Queens Park Precinct Executive Committee

28 January 2025

Moriah College Redevelopment - Modification 1 (SSD-10352-MOD-1)

1 ELEVATION Eastern Elevation

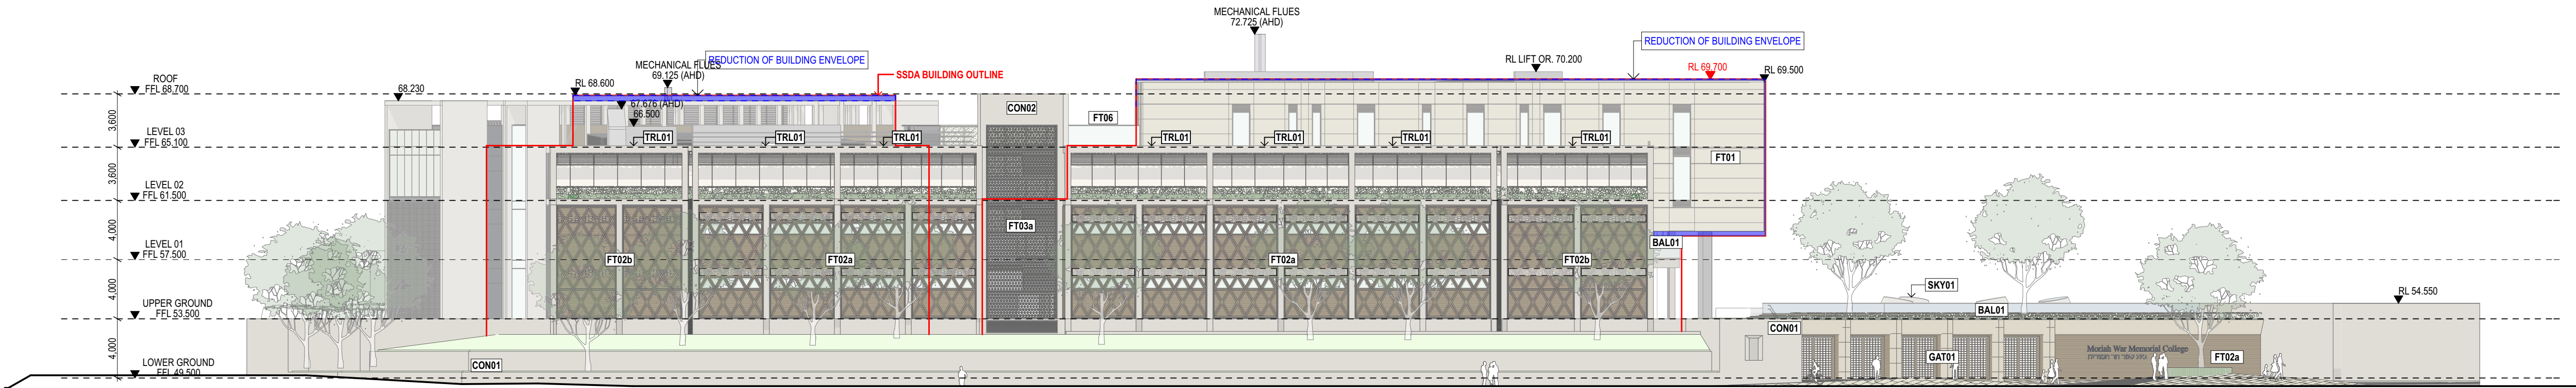
Now the approved structure is to have an additional 1.2m added to the height. While it will be recessed slightly from Baronga Ave, the proposed modification would have an even more intrusive impact when viewed from Queens Park, especially with the removal of trees along Baronga Ave. See *illustration attached*
